**Our Case Number:** ABP-317660-23

**Re:** Bus Connects Kimmage to City Centre core bus corridor scheme  
Kimmage, Dublin

## St Martins Residents Association

Ref: An Bord Pleanála Case Ref: 317660  
Bus Connects Core Bus Corridors / 11 Kimmage to City Centre Core Bus Corridor Scheme.

Programme Title BUSCONNECTS DUBLIN CORE BUS CORRIDORS INFRASTRUCTURE WORKS			
Drawing Title KIMMAGE TO CITY CENTRE CORE BUS CORRIDOR SCHEME GENERAL ARRANGEMENT			
Drawing File Name BCIDD-ROT-GEO_GA-0011_XX_00-DR-CR-0001	Sheet Number 01 of 14	Status A	Rev M01

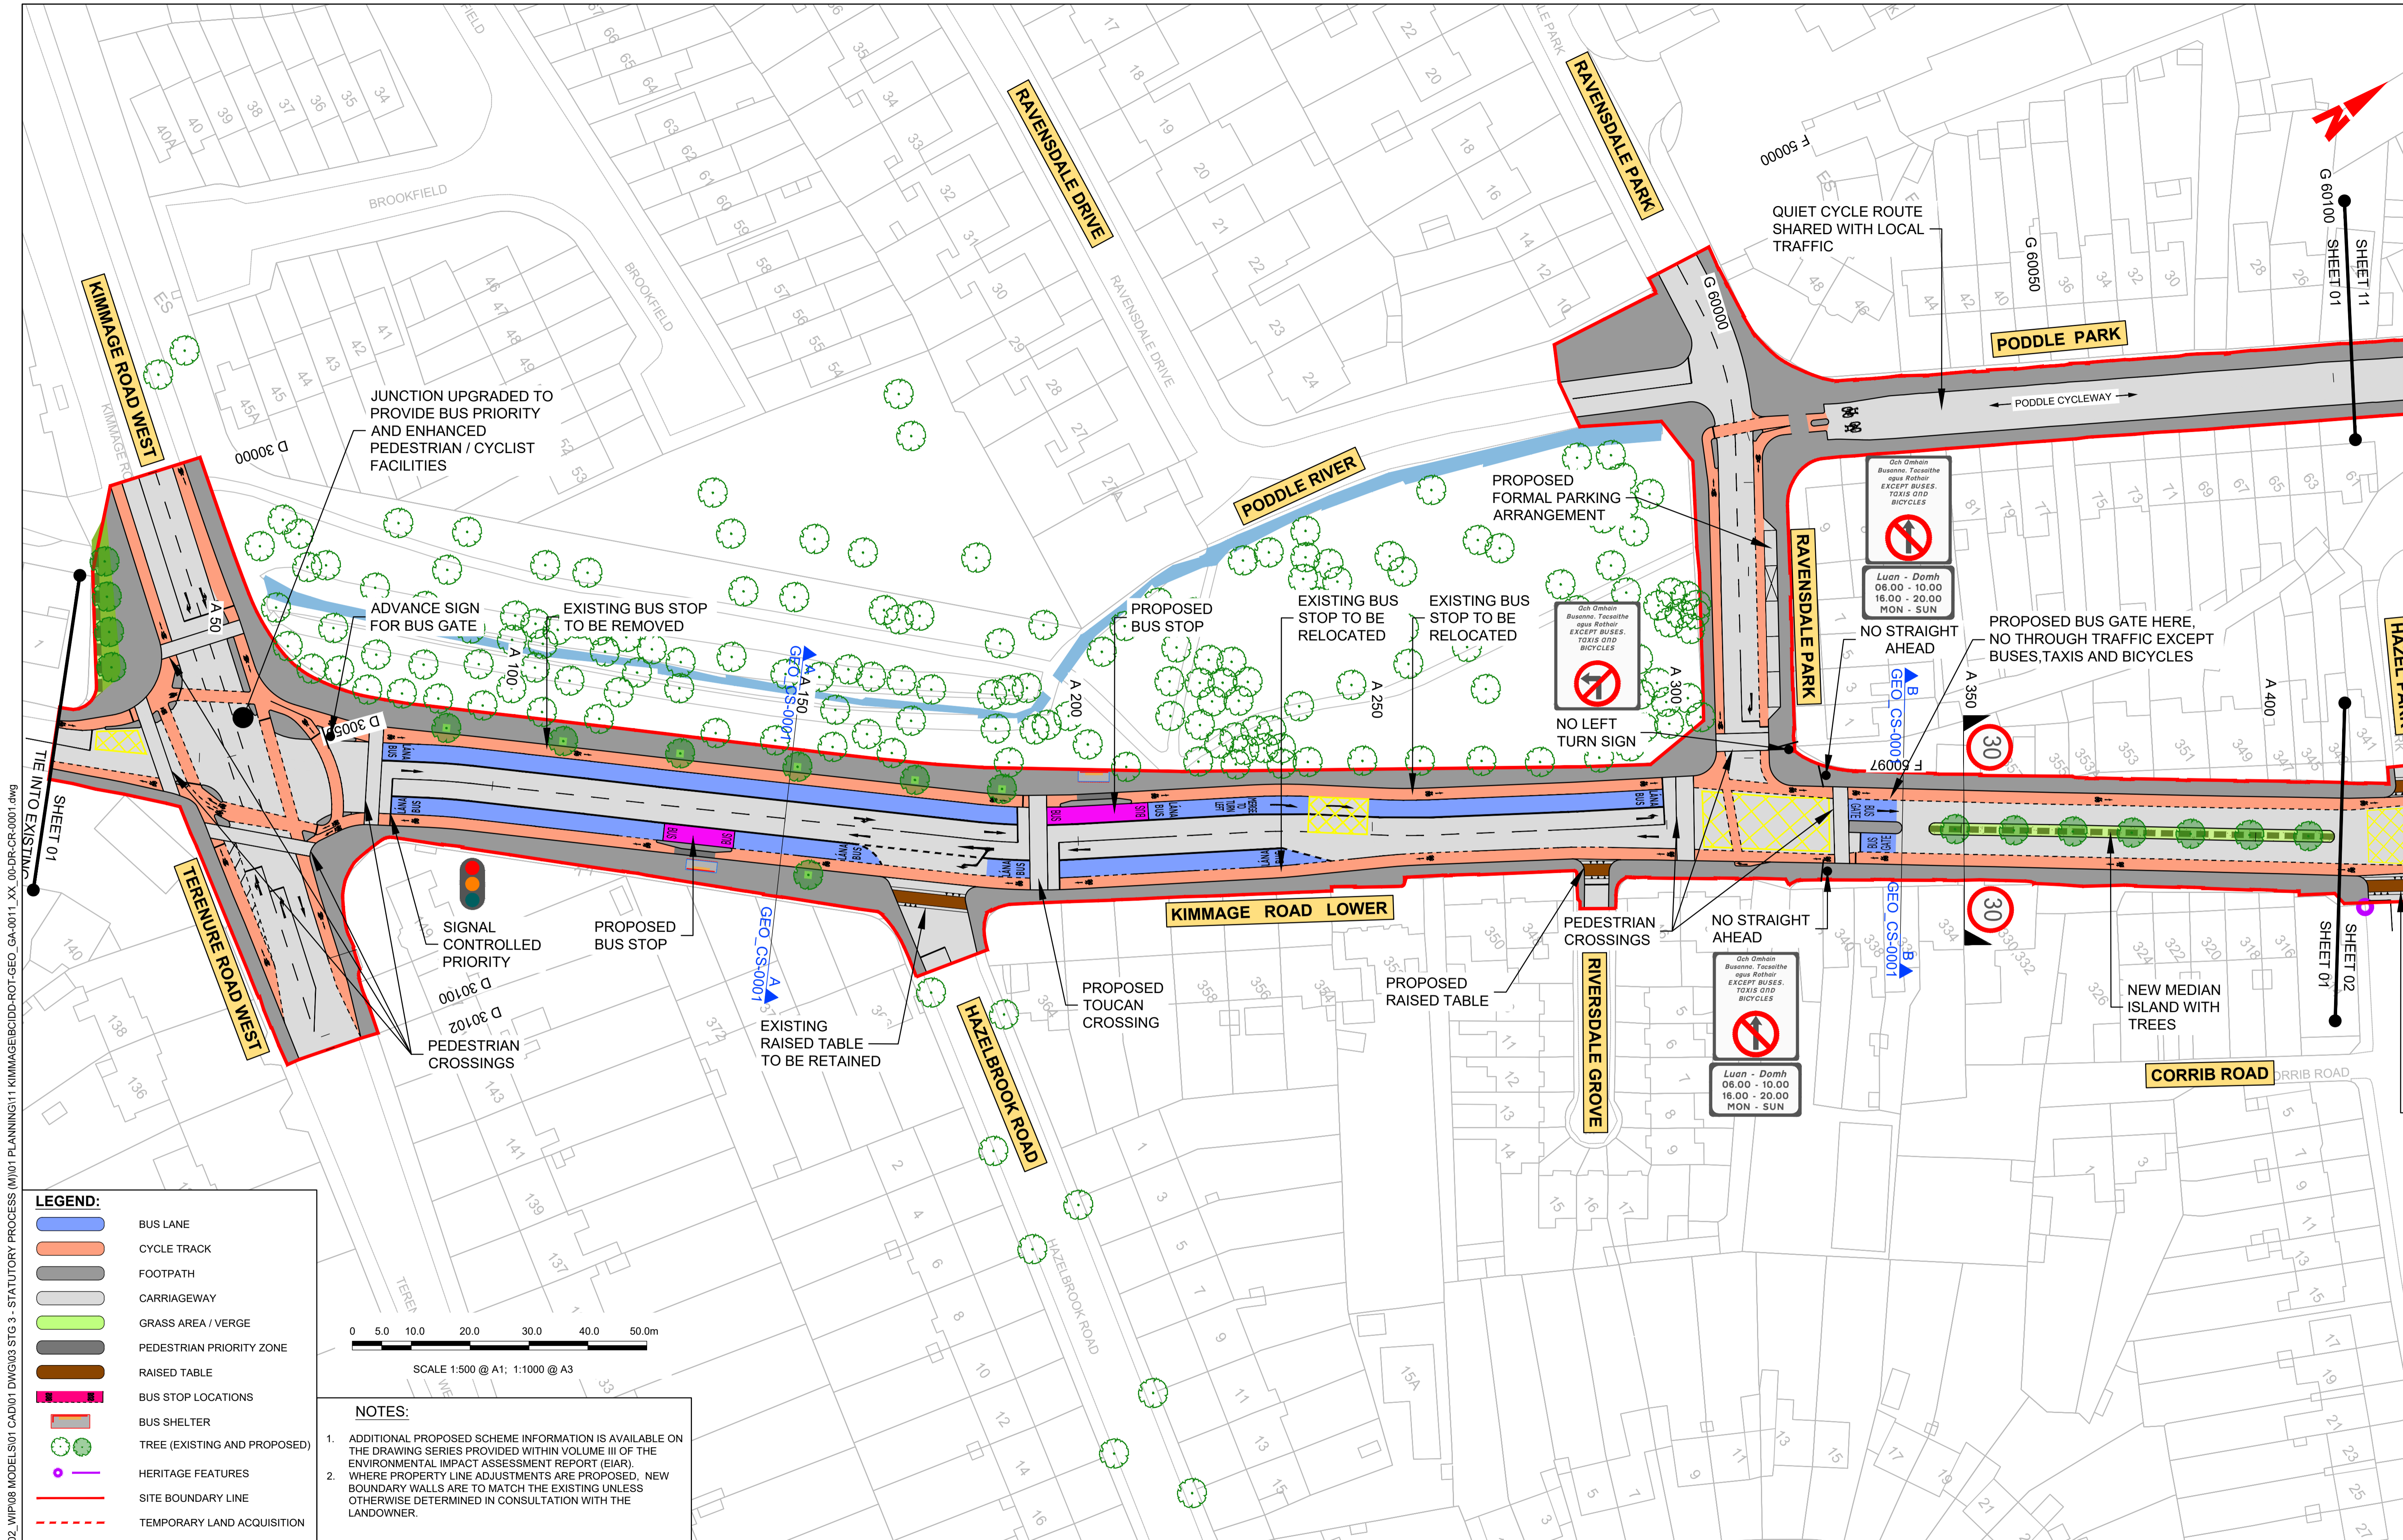
The proposed Bus Gate at Ravensdale Park North of the Kimmage Cross Roads (Sheet No 1, EIAR Volume 1 General Arrangement Drawings)

*“The Proposed Bus Gates in both directions are to be operational between the peak hours of 06:00-10:00 and 16:00 -20:00 Monday to Sunday.”*

The residents welcome that the operational times have been altered to peak times only, but submit that the inclusion of Saturdays and Sundays to the peak times is unnecessary, too restrictive and disproportionately affects the residence living in the vicinity.

There is no impact assessment, or consideration / analysis of the consequential impact on the surrounding area of the restrictions on the residents, whose homes are located within the bus gate locations.

Drawing File Name	Sheet Number	Status	Rev
BCIDD-ROT-GEO_GA-0011_XX_00-DR-CR-0002	02 of 14	A	M01

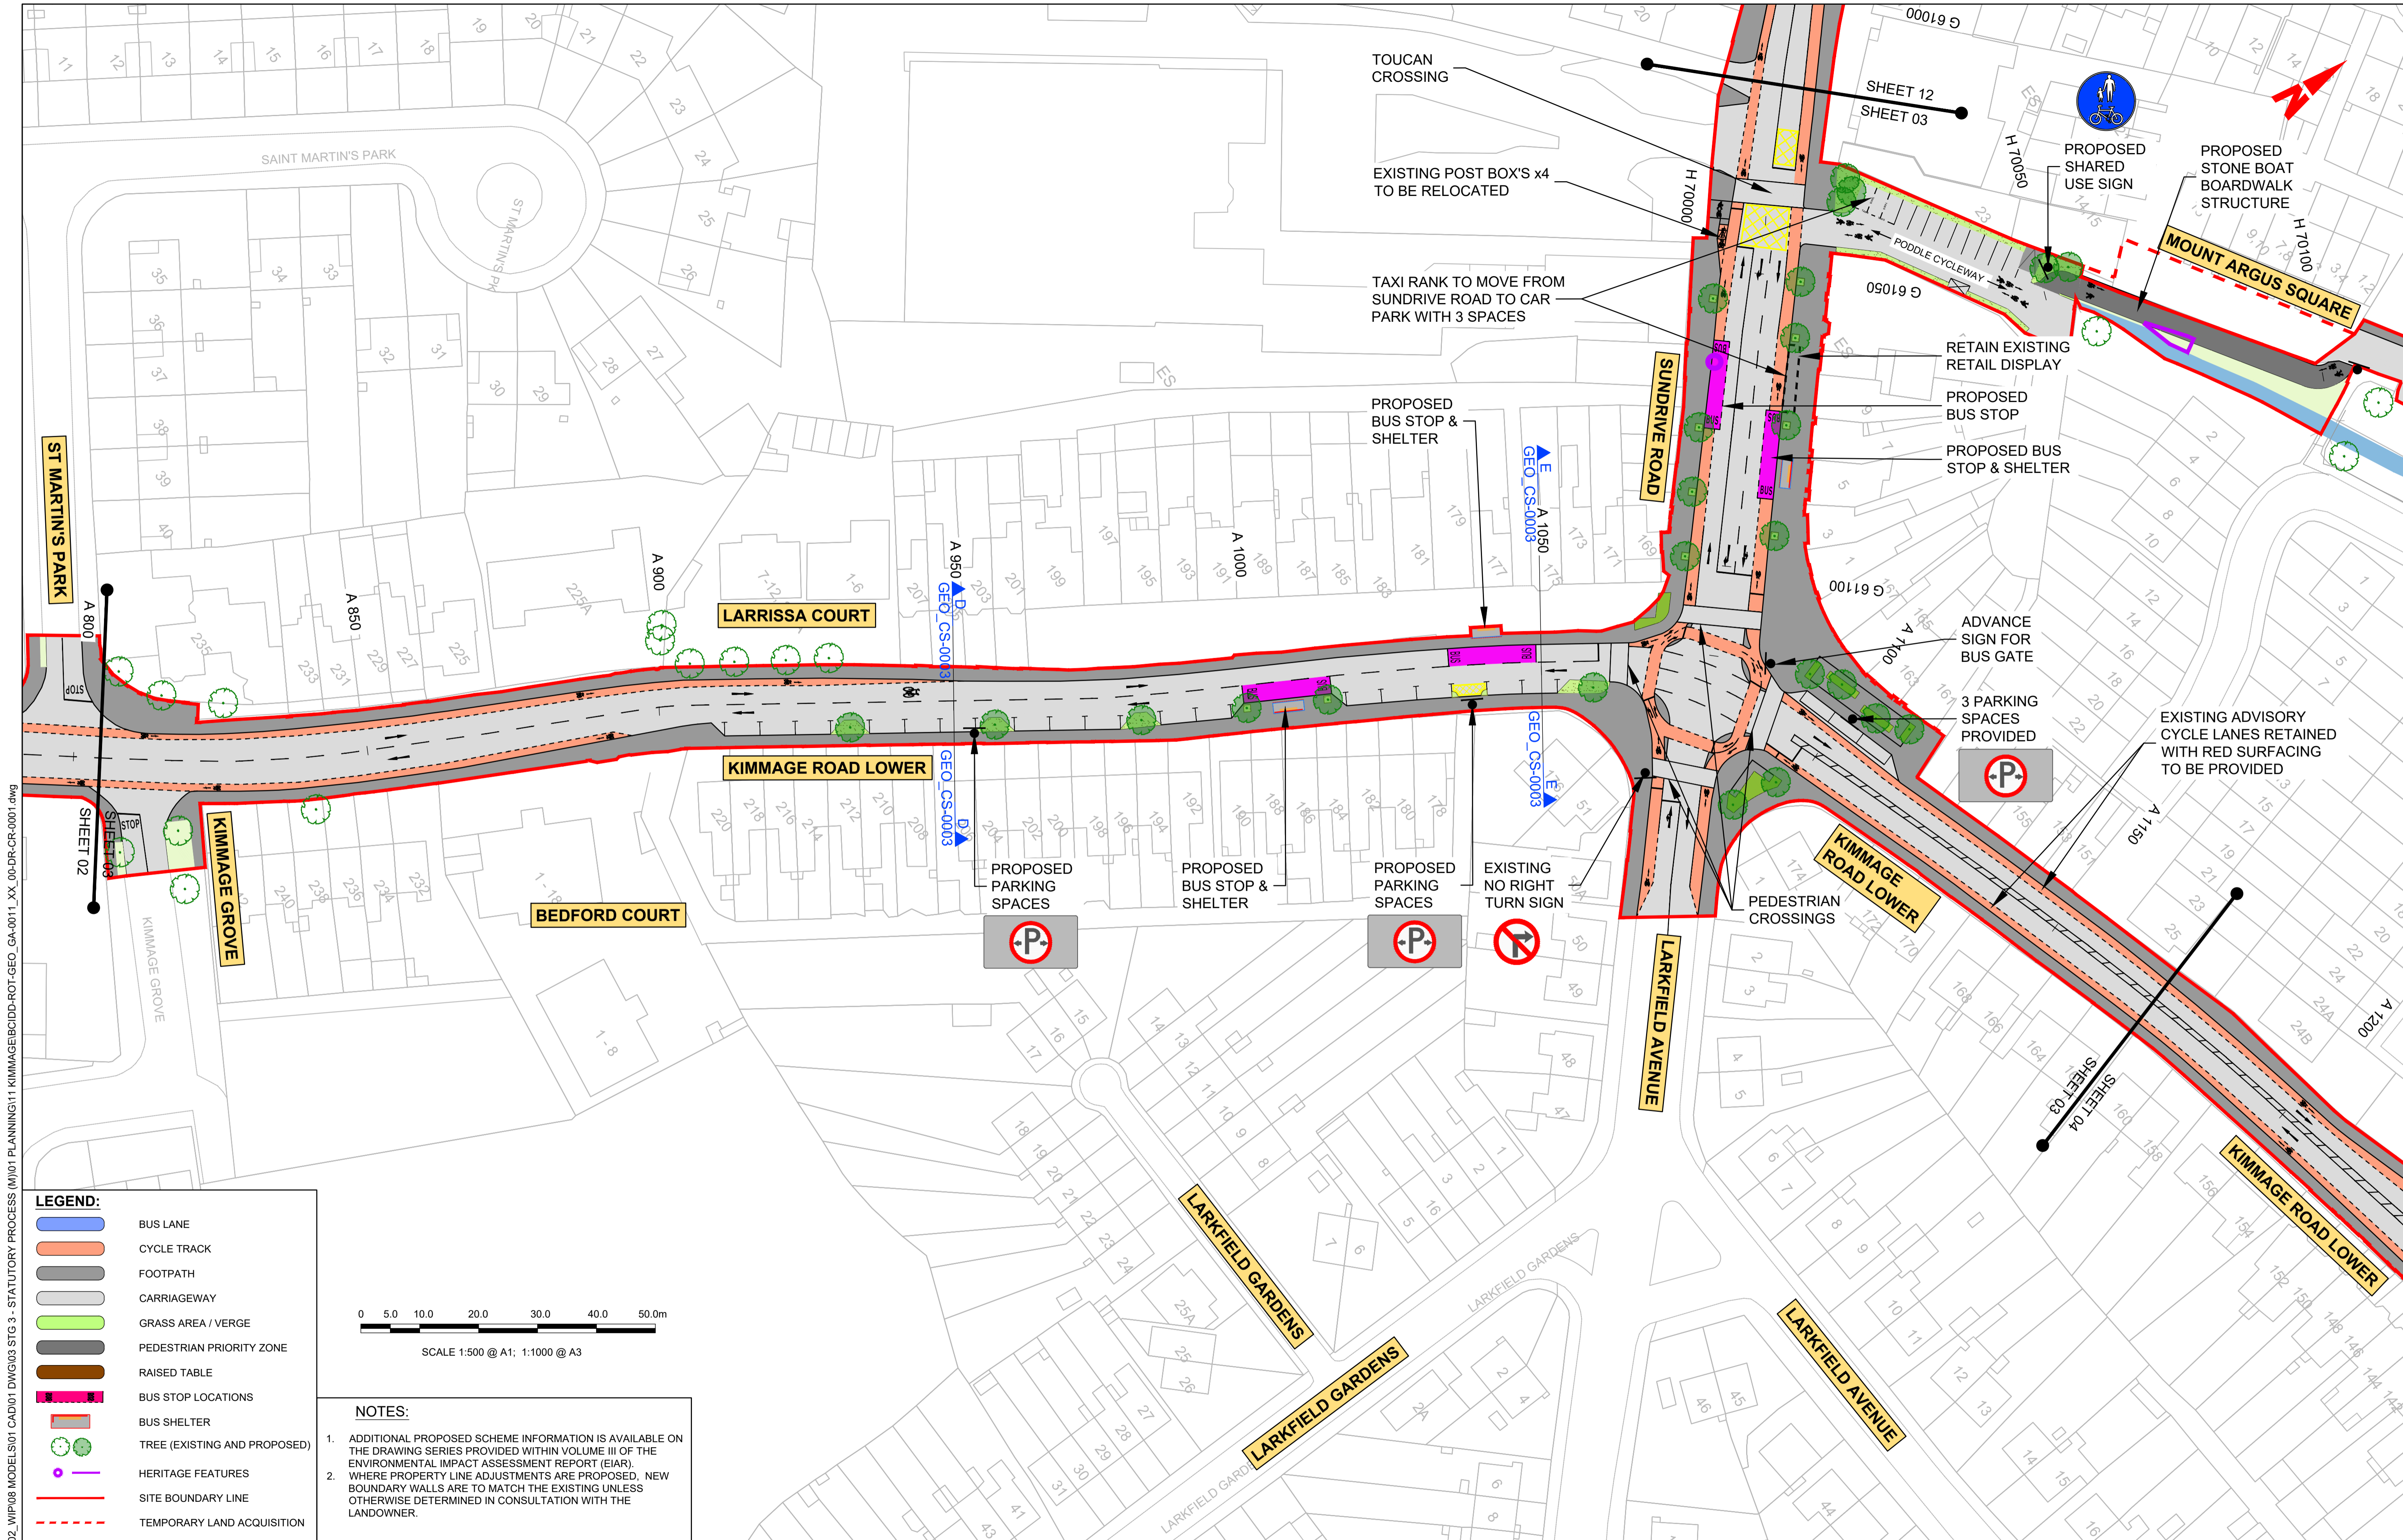
### 2. Provision of Cycle Lanes Sheet No 3

It would appear from the extract shown above that the existing advisory cycle lanes have been removed in the Northern direction from No 207 Lr Kimmage Road and in the Southern direction from Bedford Court, which is contrary to all sections of the submitted reports and intentions of the scheme.

Can the designers of the scheme indicate what is the intension – are cyclists using these routes to dismount? Carry out dangerous manoeuvres and merge into the traffic?

Why have the proposed advisory cycle lanes been removed in favour of more car parking?

We submit that the existing road is not wide enough to provide for additional parking, traffic lanes which buses will be using and the existing advisory cycle lanes and is extremely dangerous for any cyclist to have to compete with buses, private cars and parked cars on a narrow road lane.

There is no impact assessment on the removal of these advisory lanes, no consideration or analysis of the consequential impact on the cyclists using the lanes and how the removal mid route will be dealt with. We would submit that all existing advisory cycle lanes be retained and not altered with in bus gates as it is stated in the EIAR but is contradicted in the general arrangement drawings.

We note on the general arrangement drawings that an additional 17 No car parking has been included on the Southern route outside the existing properties Nos 176 to 220 Kimmage Road lower.

It appears from the general arrangement drawings that the cycle lanes have been omitted to facilitate these additional spaces, as discussed above -Provision of cycle lanes (Sheet No 3 Volume 1 General Arrangement Drawings).
